One Earth Solar Farm

**Final Statement of Common Ground with Anglian Water
Services Ltd.**

EN010159/APP/8.13.3

December 2025

Figure 2.1 Site Access Location Plan

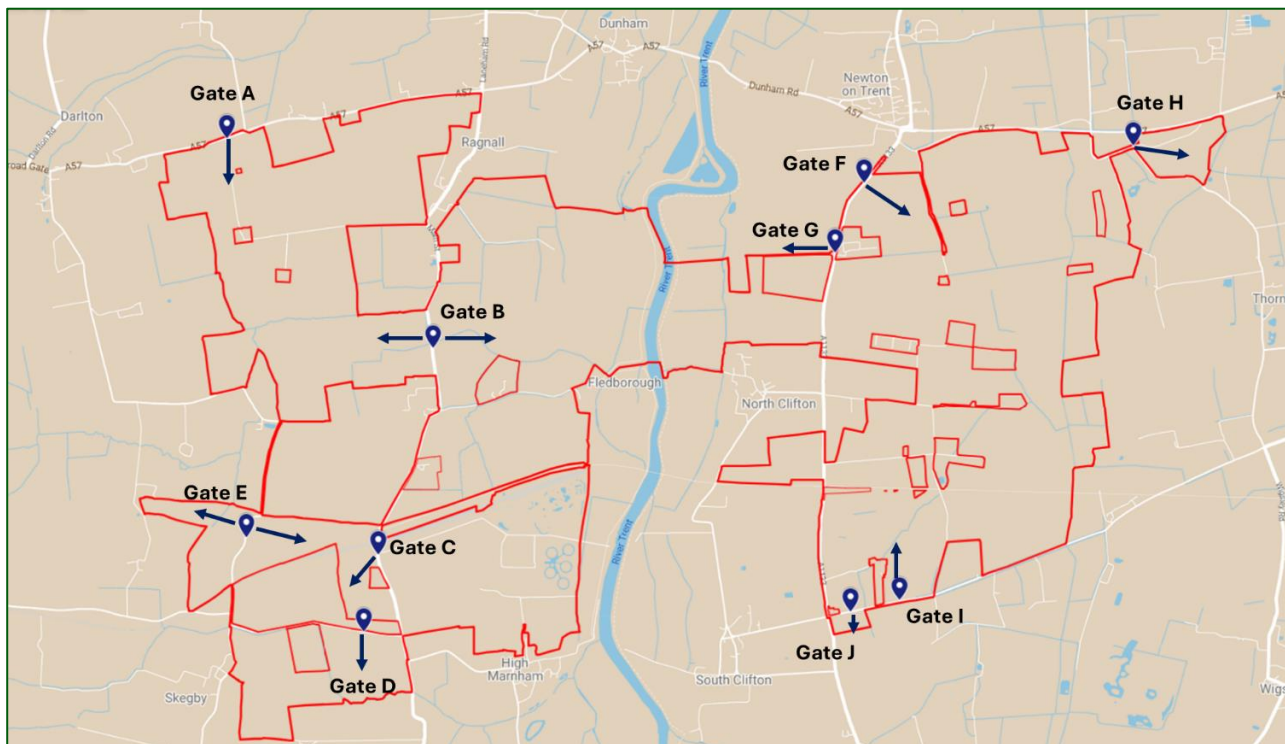
Ref.	Description of Matter	Stakeholder Comment	Applicant's Response	Status
03-06	Proposed access point (Gate G) off the A1133 in the vicinity of Water Reservoir and Hall Water Treatment Works	The masterplan document shows a proposed access point (Gate G) adjacent to the Hall Water Reservoir and this would involve crossing over AWS's pipeline assets. It is proposed to widen the access road and create visibility splays on the track running parallel to the reservoir.	A clarification has been added to the Outline Landscape and Ecology Management Plan submitted at Deadline 5 confirming that the hedgerow north of the access track will be retained, other than a small section marked for removal as shown on the Vegetation Removal Plan in Appendix C of the oLEMP [EN010159/APP/7.7] which will be removed to facilitate the widening of the bell mouth junction. The rest of the access track is proposed to be used in its current condition and therefore no further works to the track are proposed. Therefore, there is no impact on AWS's use of the track to access assets. The Applicant has provided AWS with an access plan of Gate G, which can also be found at page 112 of the Transport Assessment [REP5-030]. The road junction works are short term and will be programmed in	Agreed

Ref.	Description of Matter	Stakeholder Comment	Applicant's Response	Status
			agreement with Anglian Water. Beyond these works, there are no road closures planned for the project and the likelihood of disruption is minimal. Access for emergency works will be unimpeded by the Applicant. The access at Gate G is for landscaping and biodiversity works, and the expected quantum of traffic will be very low, thus unlikely to have any impact on your operational access. The Applicant has confirmed within the oCTMP submitted at Deadline 7 the following – <i>“Engagement with Anglian Water Services and other utilities services where necessary, will be undertaken on a regular basis to ensure their access to their existing and new assets is available throughout the construction period. This is with reference to, but not exclusive to Hall Water Treatment Works and Reservoir. This is to</i>
